**KIRKLEES METROPOLITAN COUNCIL
INVESTMENT & REGENERATION SERVICE**

Reference No: 2020/62/90133/E

Site Address: 1, Chapel Royd, Emley, Huddersfield, HD8 9GN

Description: Erection of extension to garage and front and rear dormer windows

title general arrangement as proposed
number 15072D-11-P01
scale 1:50
size A1

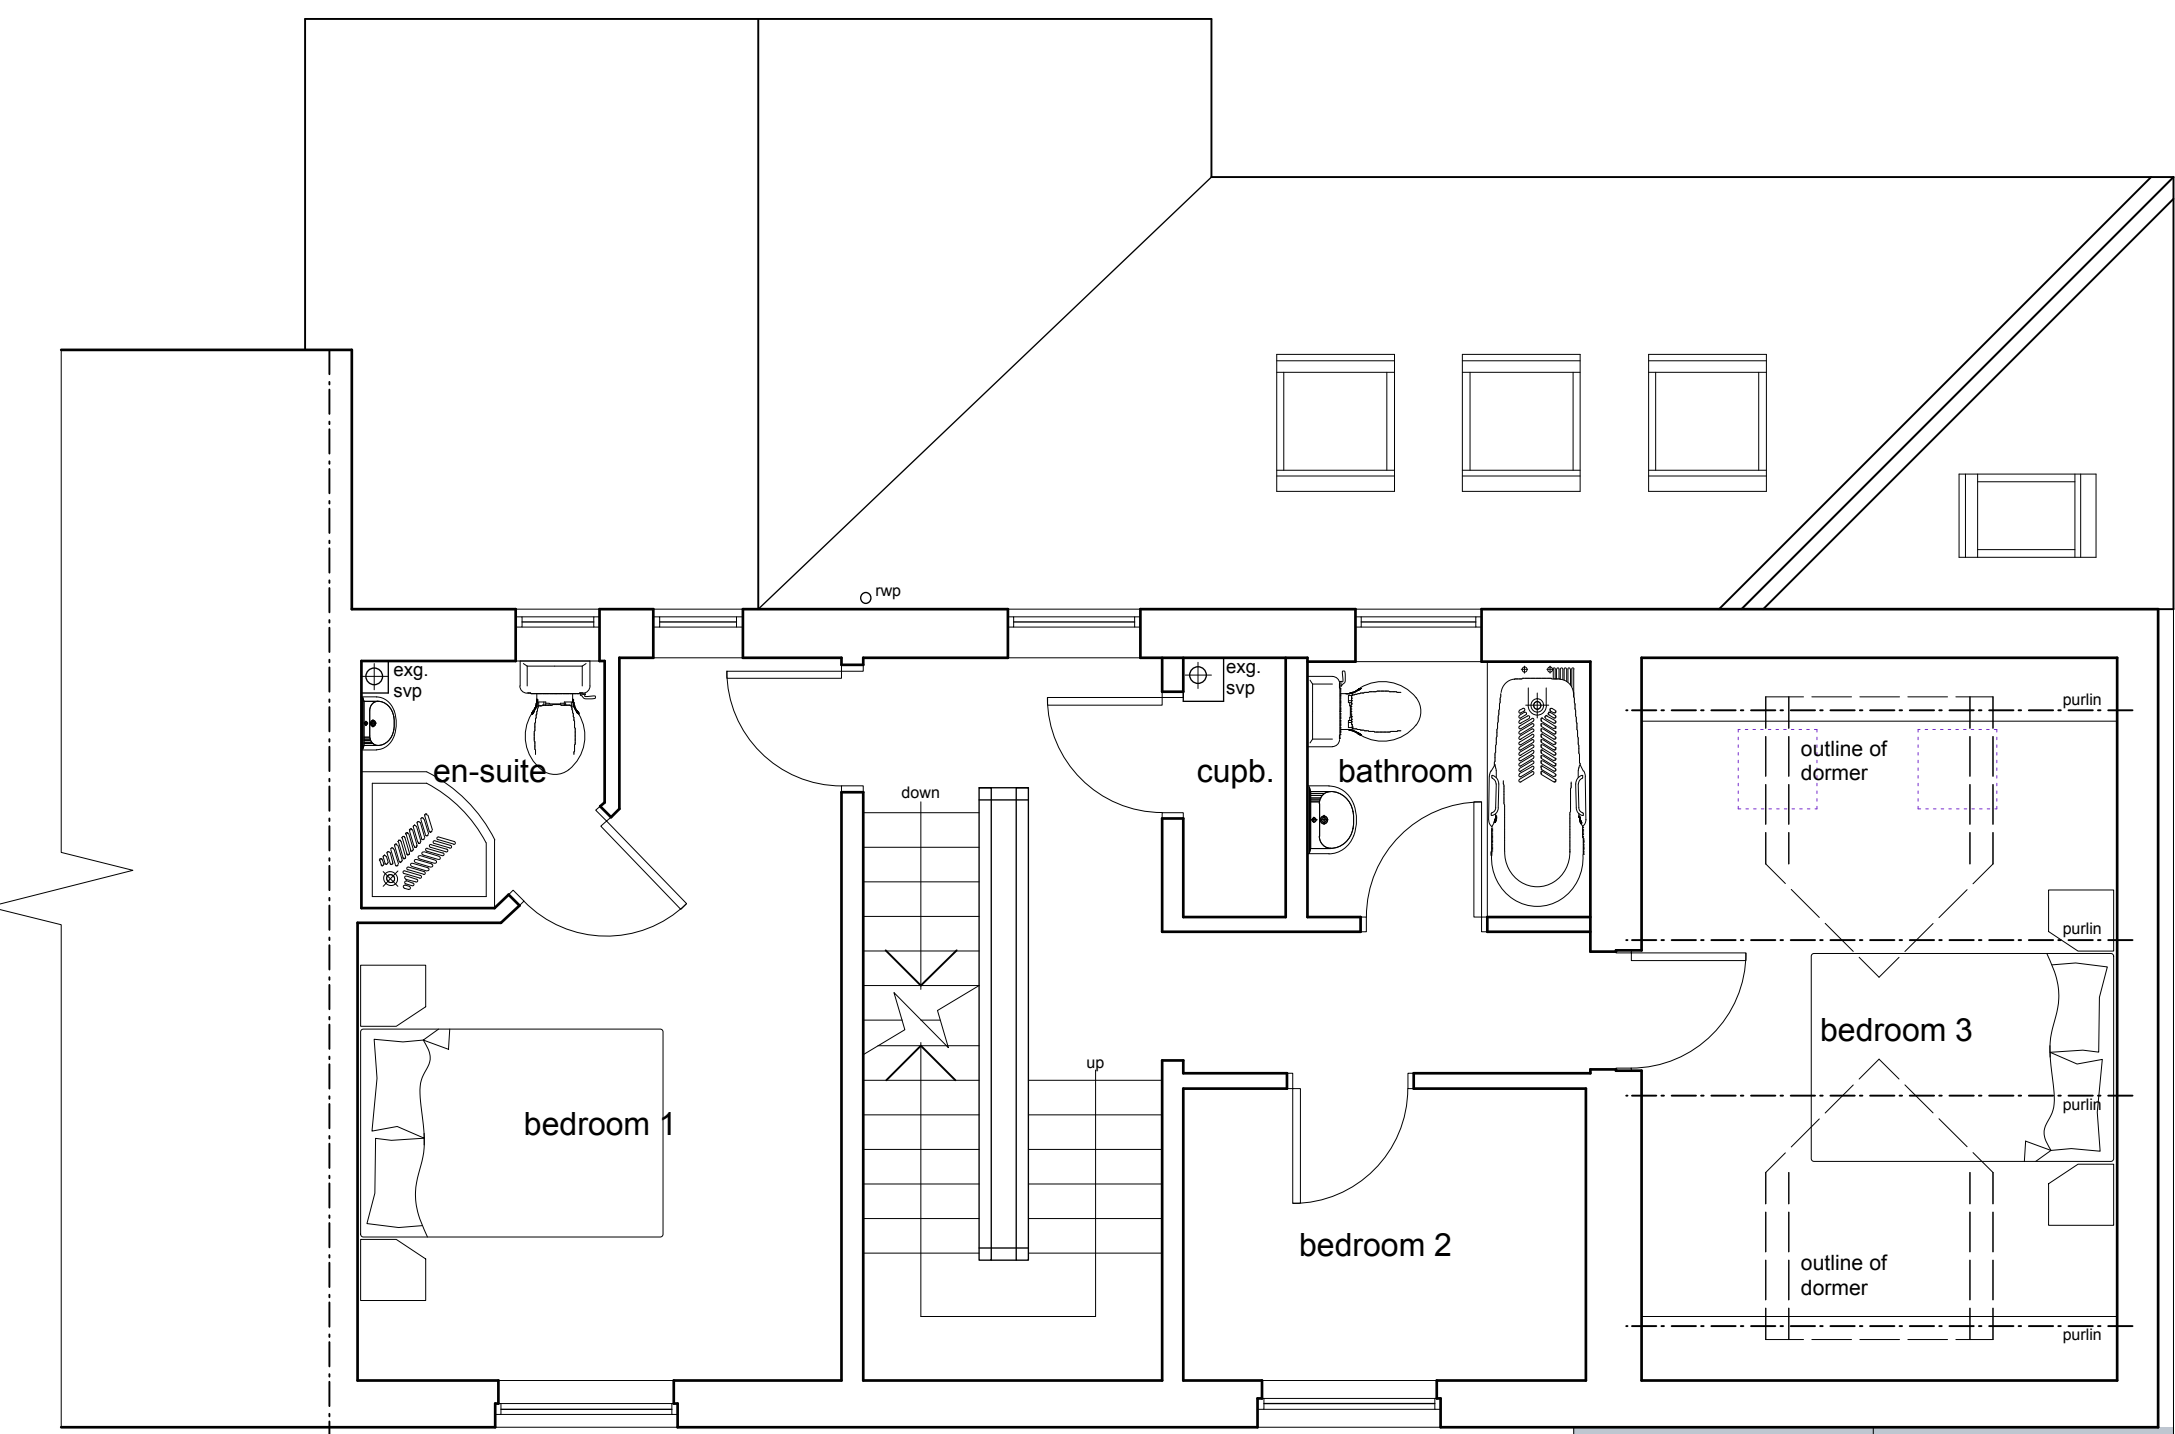
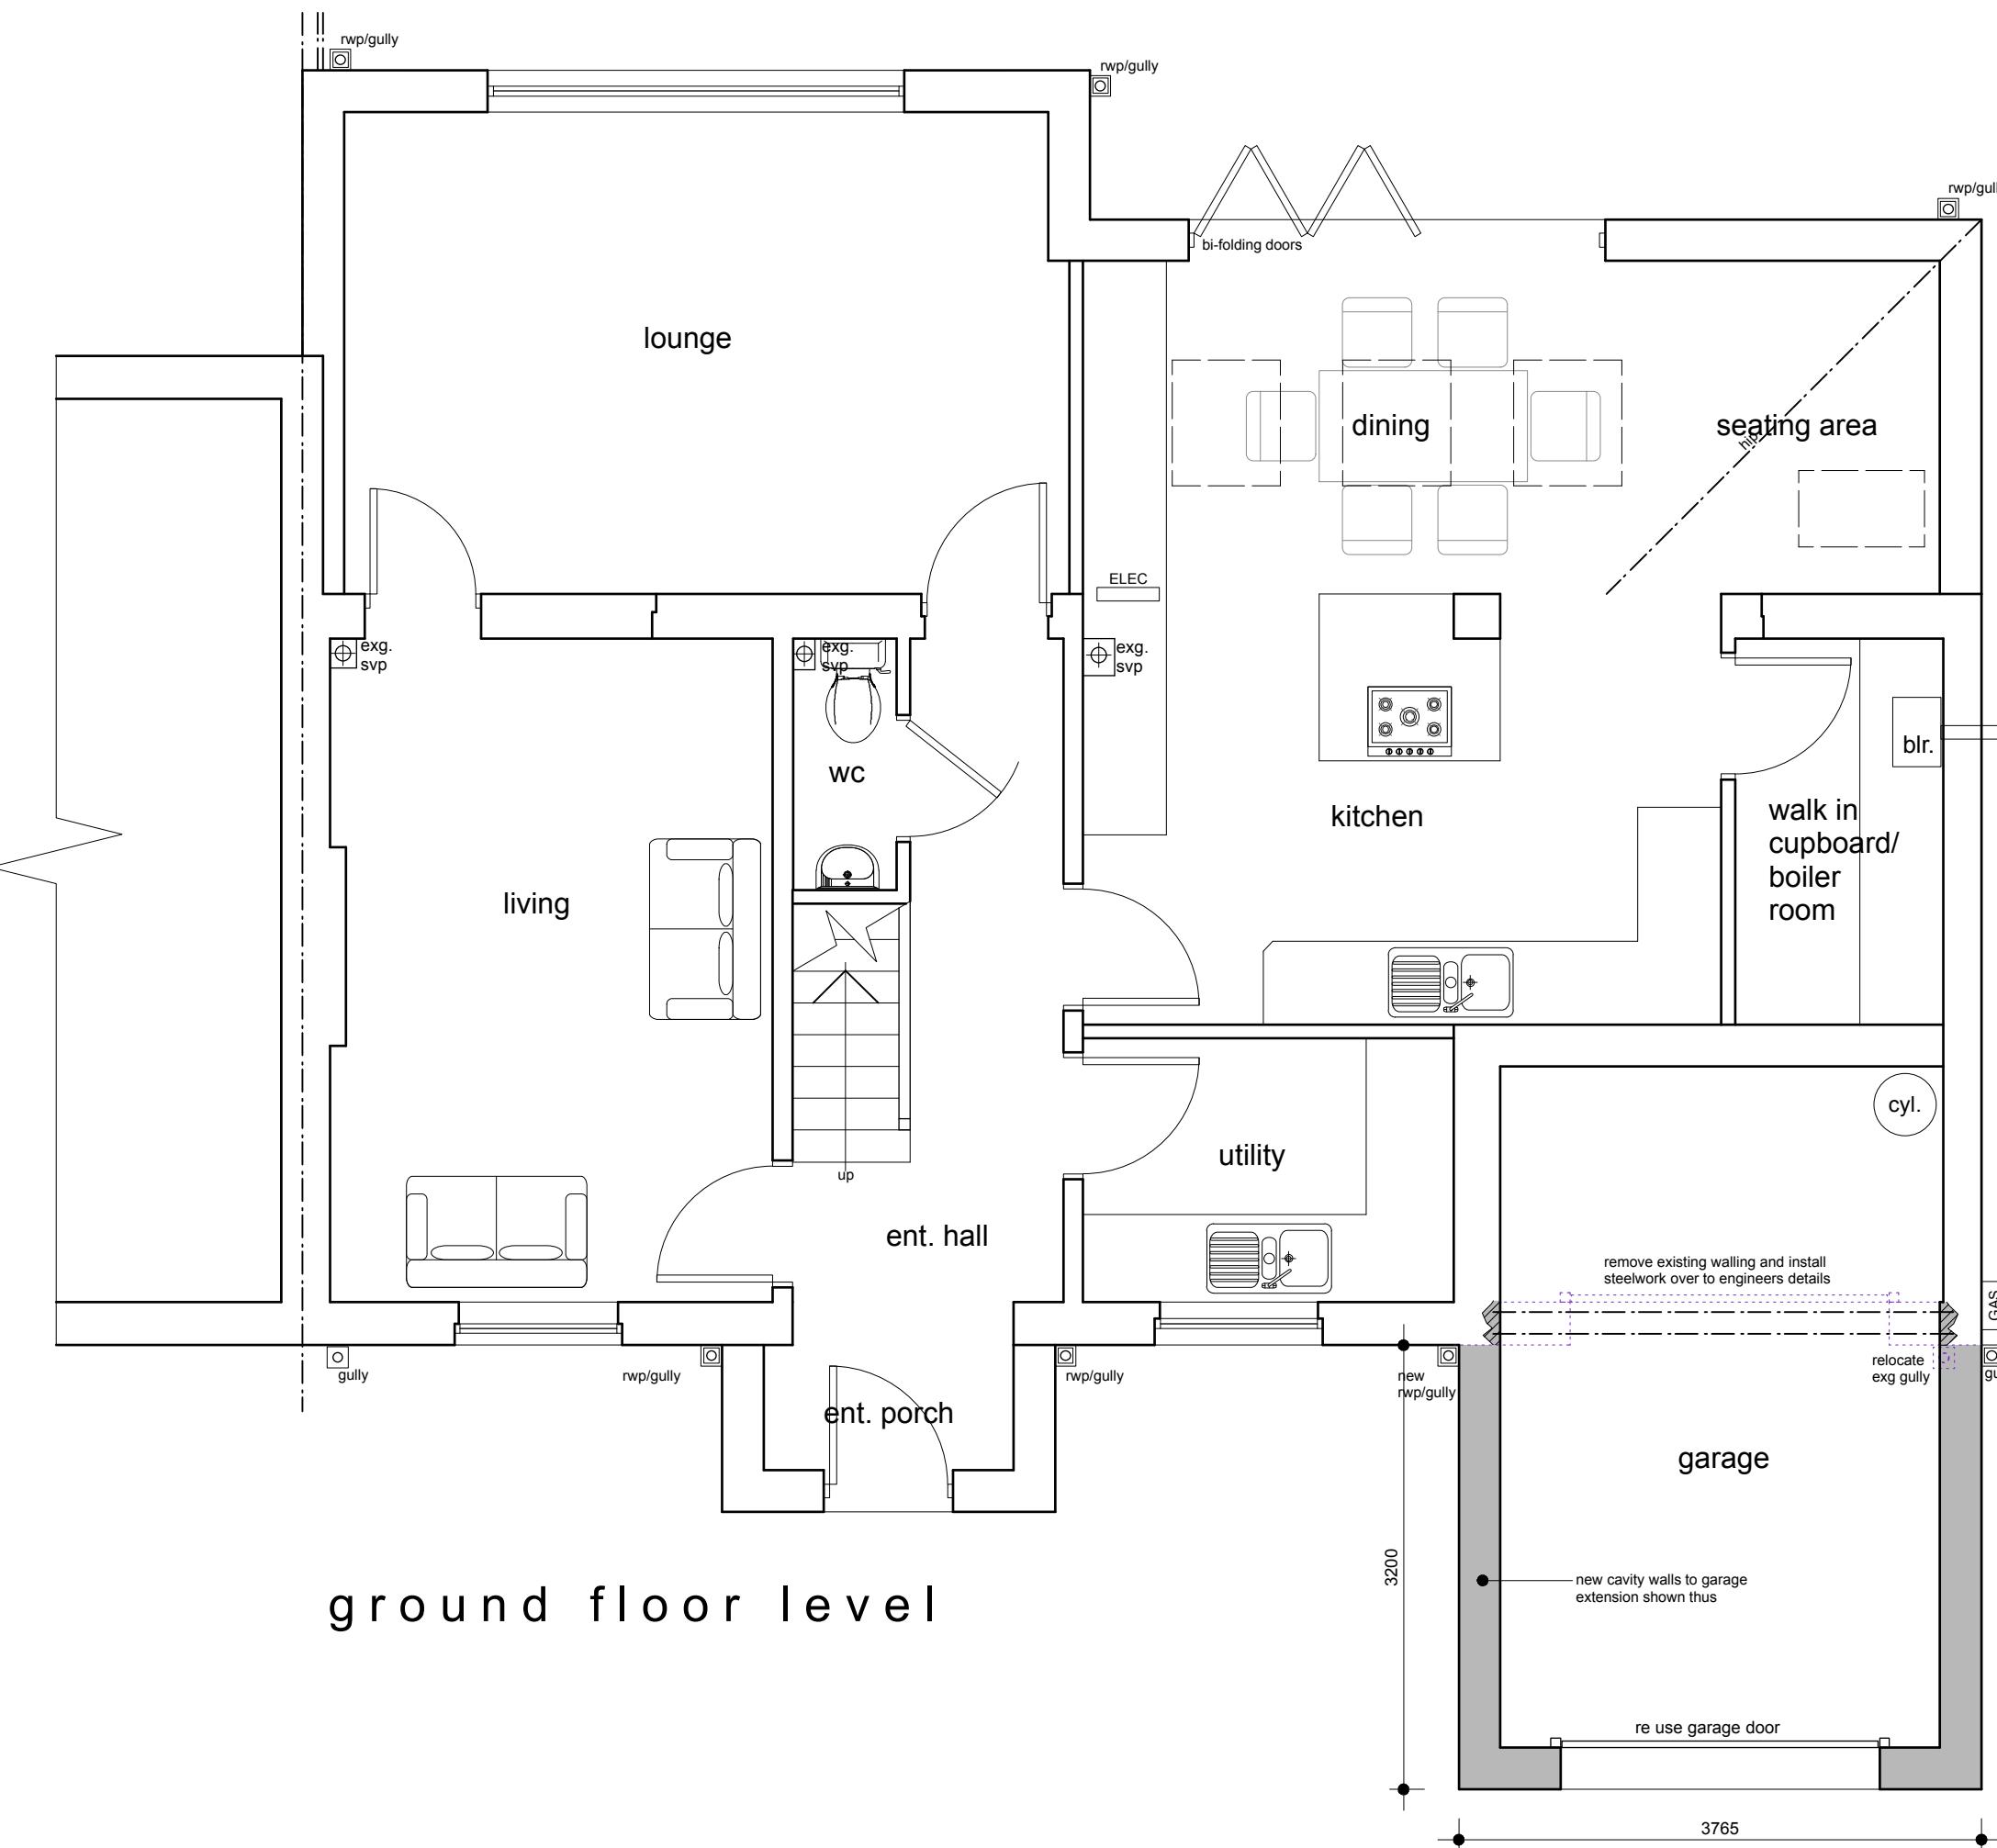
Officers raised concern with the agent regarding the relationship between the garage extension and the host property and suggested that this element be removed from the proposal. The agent submitted amended plans replacing the original gable roof form with a catslide roof form. The amended plans are considered to, on balance, address officers concerns.

Whilst the amended plans would result in a small increase in the maximum height of the garage extension, as a result of the introduction of a catslide roof form, it is considered that the overall impact on the adjacent properties would be reduced. As a result, and due to the nature of the amendments which replace the proposed roof form of the garage extension, it was not considered necessary to advertise the amended plans in this instance.
